Application no: 21/02496/DISC

Location: Land to The South And Adj To, South Side, Steeple Aston

Transport Development Control

HIGHWAY CROSSOVER FROM SOUTH SIDE  
Scale 1:20

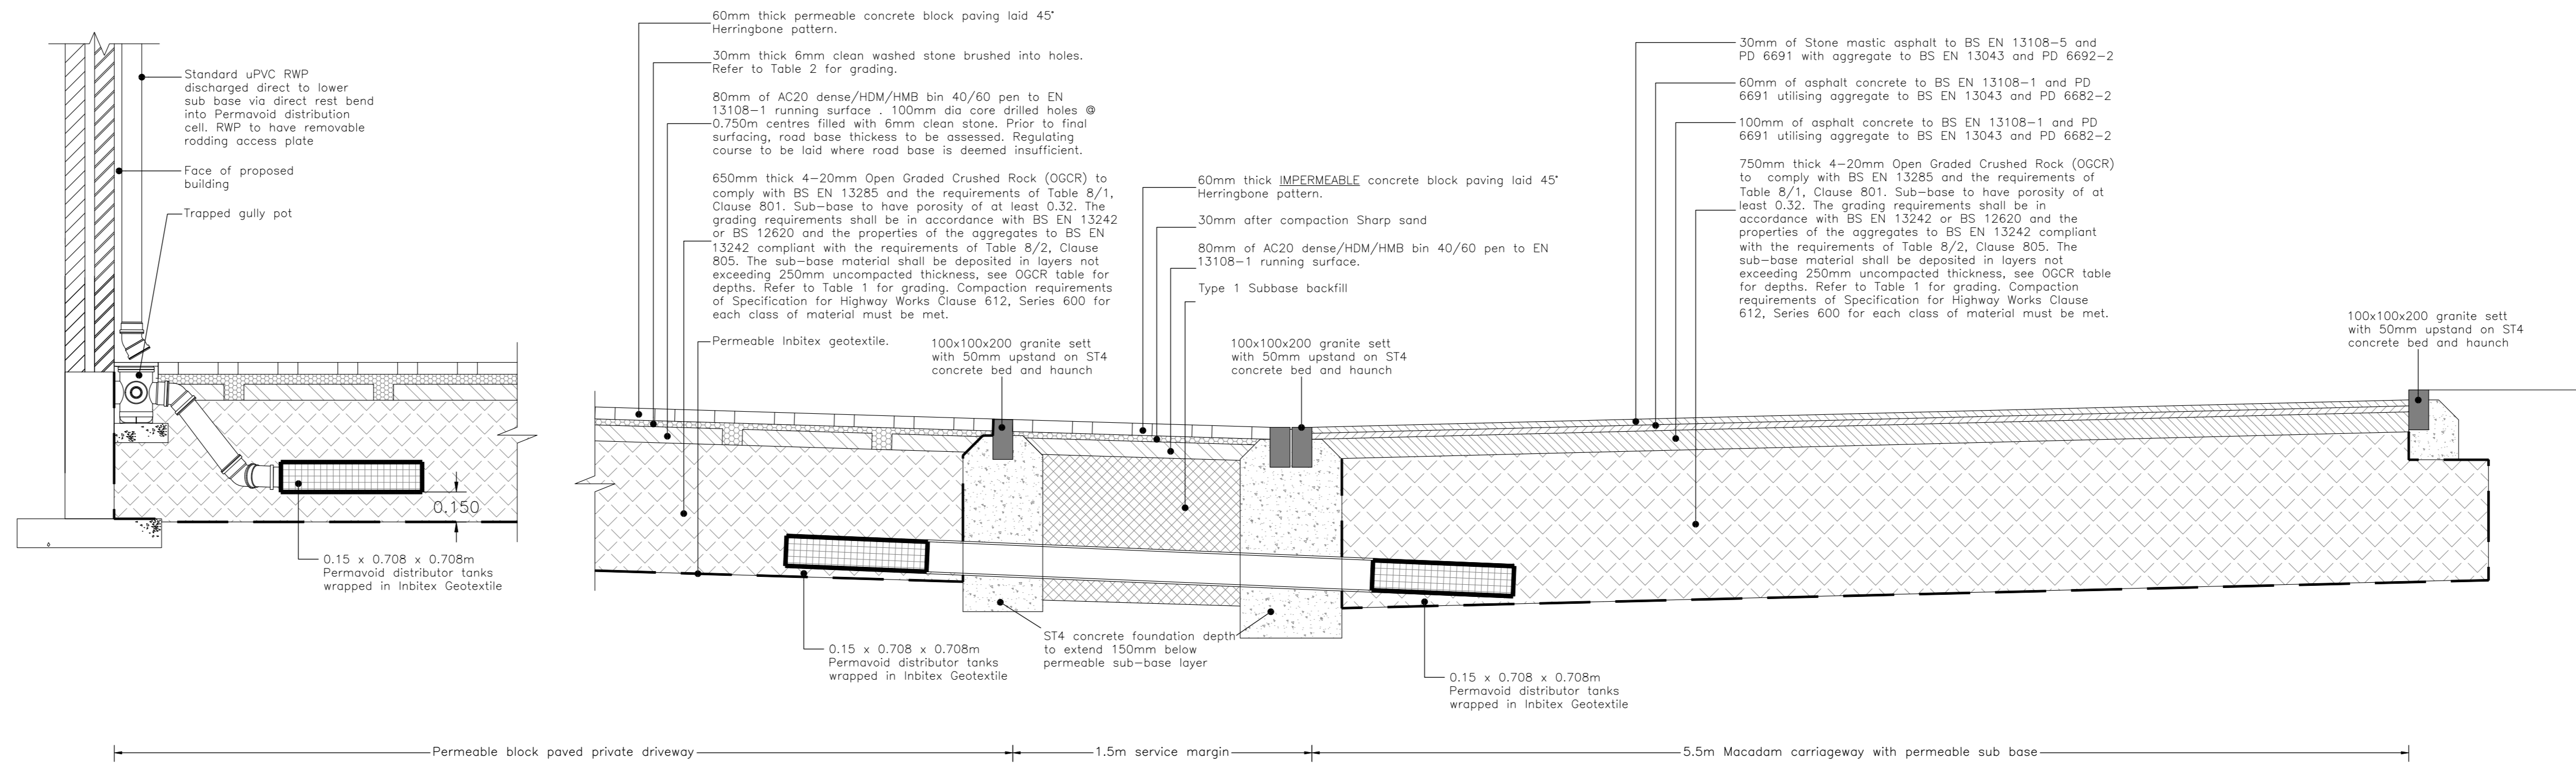
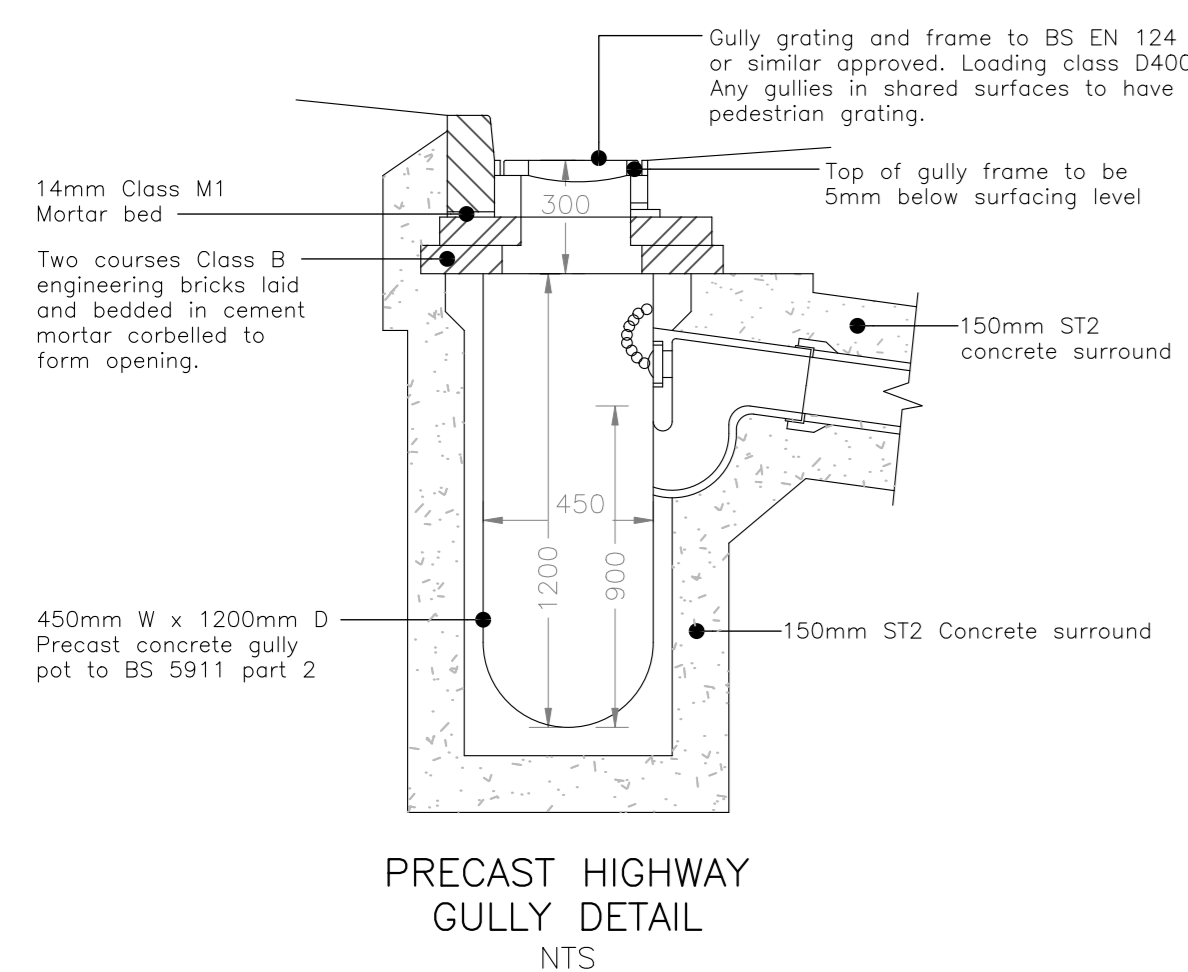
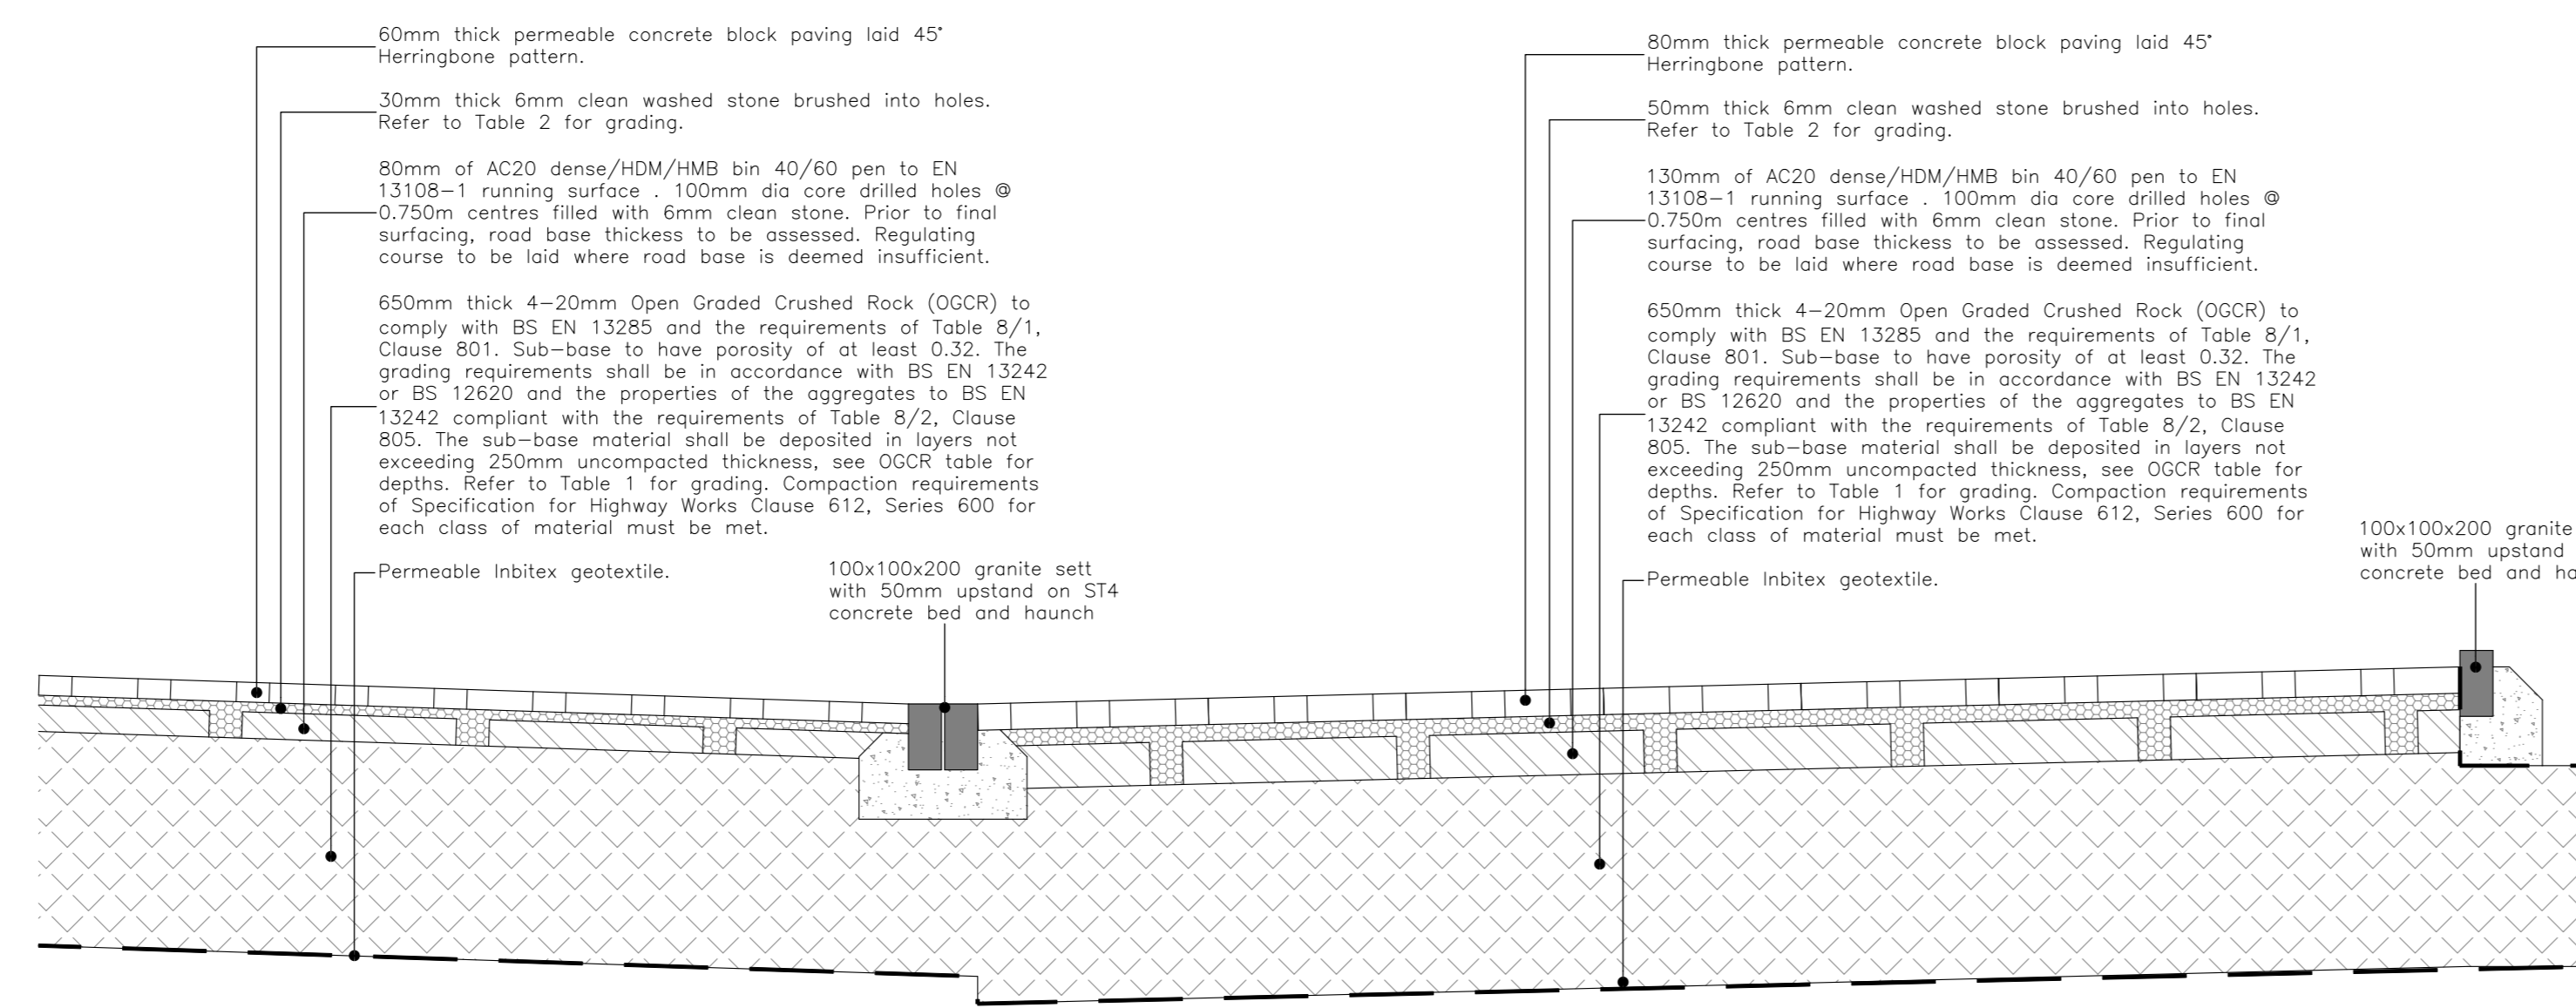
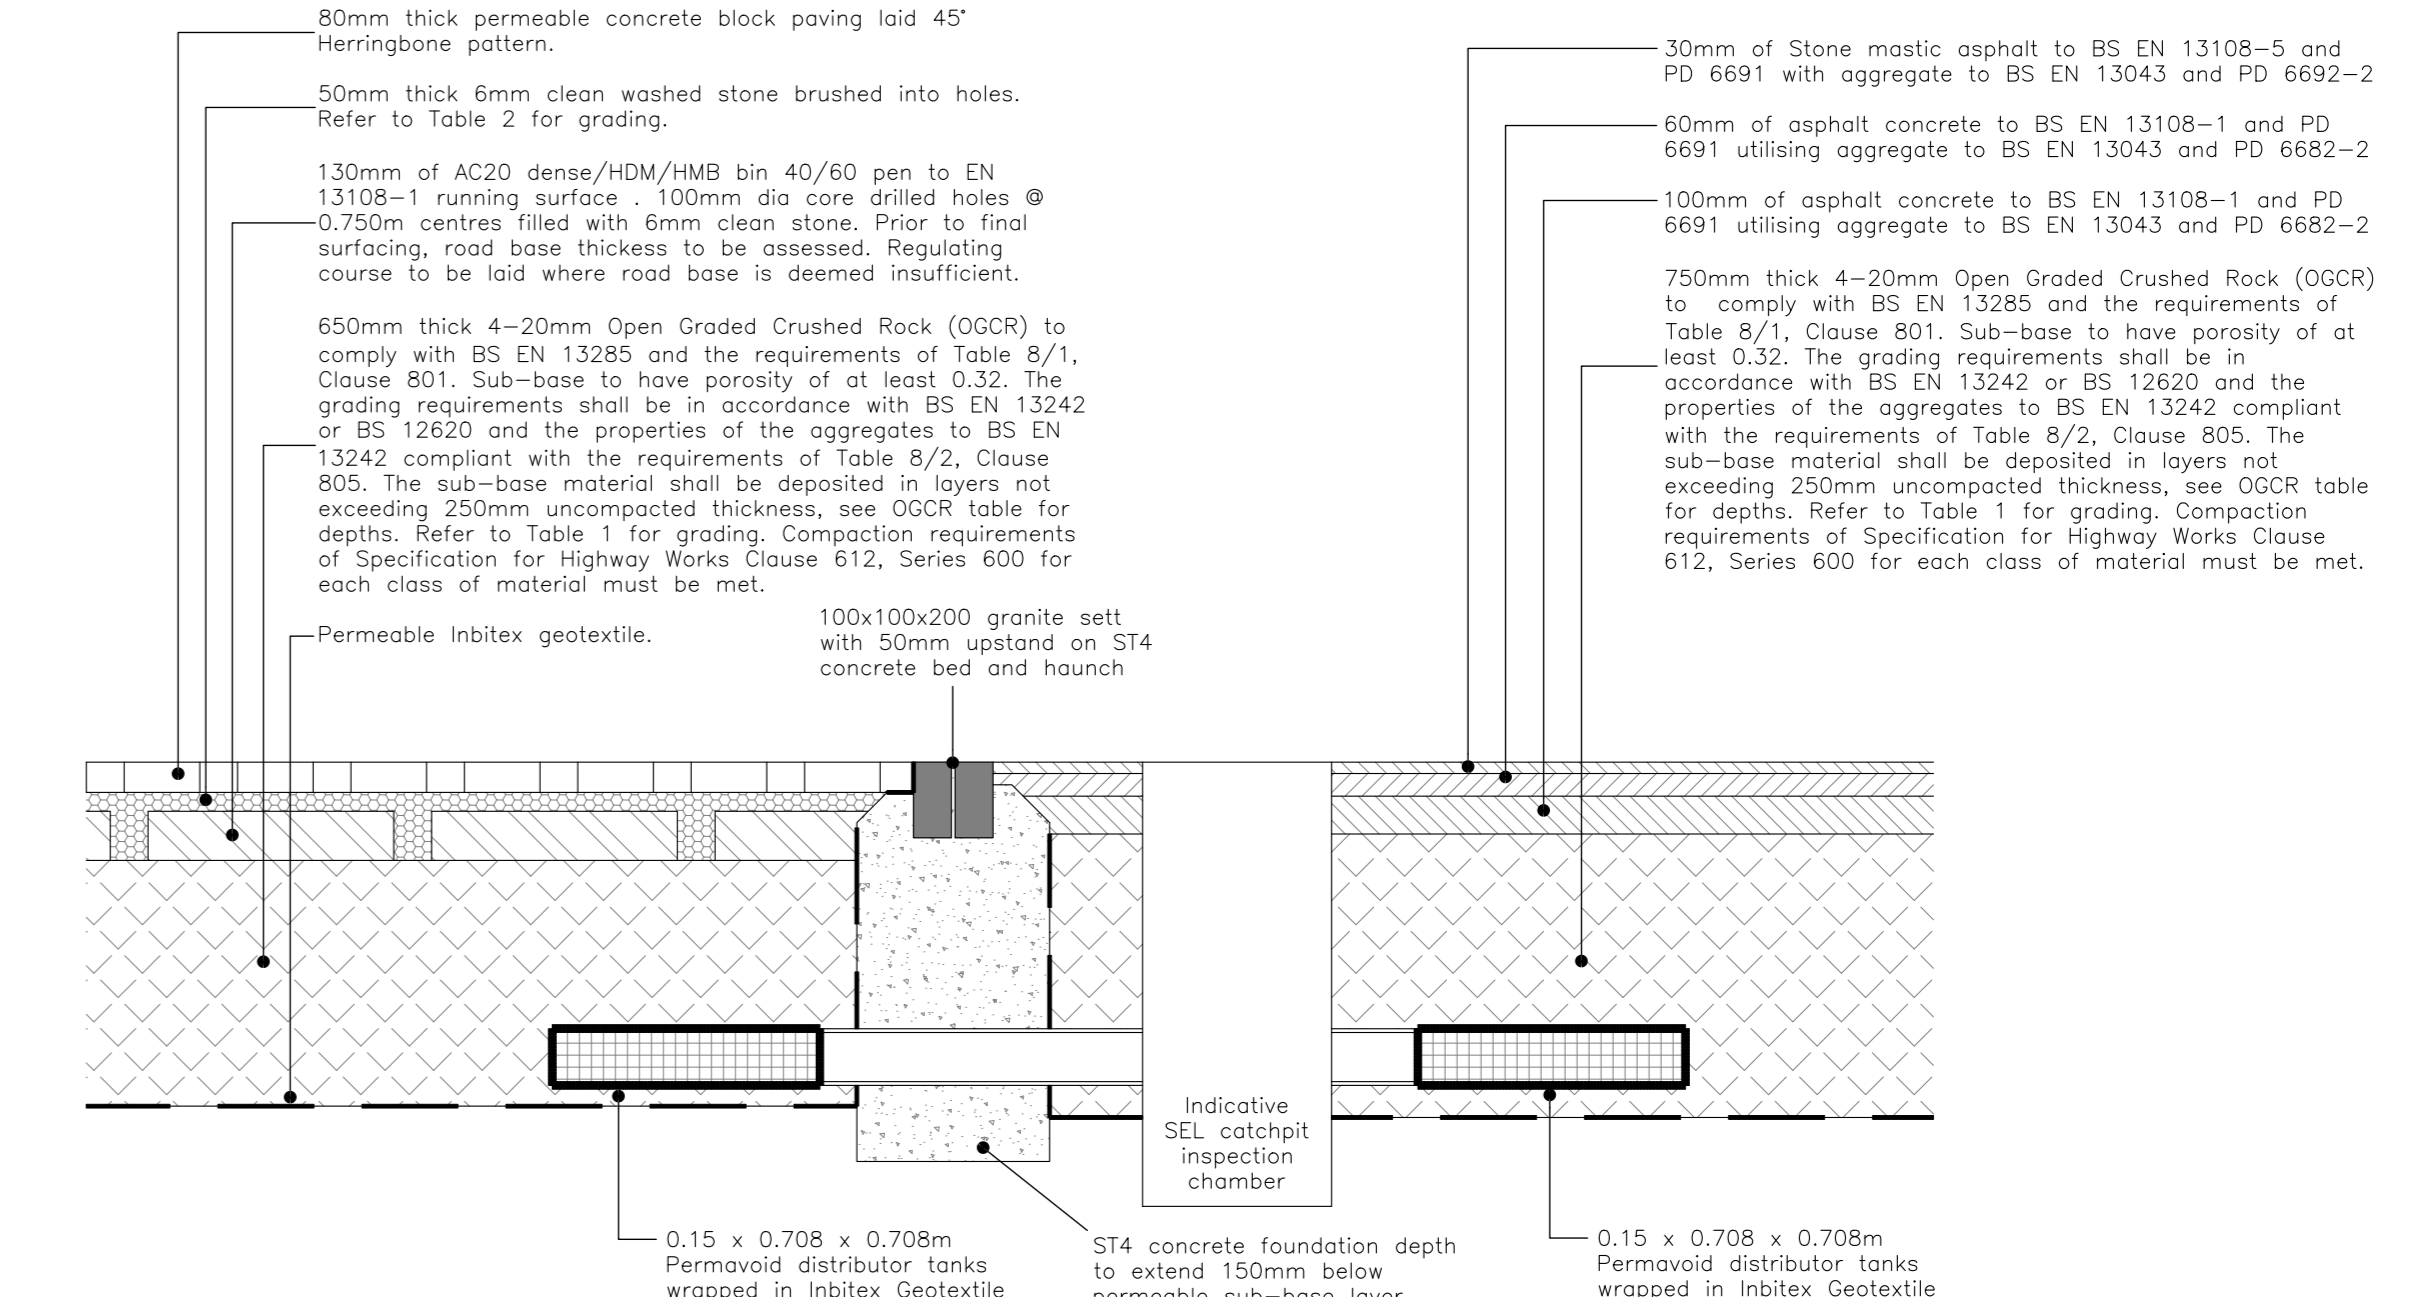
The County's Road Agreements team has not seen the internal site layout as part of the S278 technical audit process. As such, the County's Road Agreements team is unable to recommend discharge of this condition at this stage as it is not in a position to confirm whether the details submitted are suitable to satisfy the condition. **Reason for objection.**

- Condition 9 - the proposals need to be subject to the County's S278 technical audit process before this condition can be discharged.
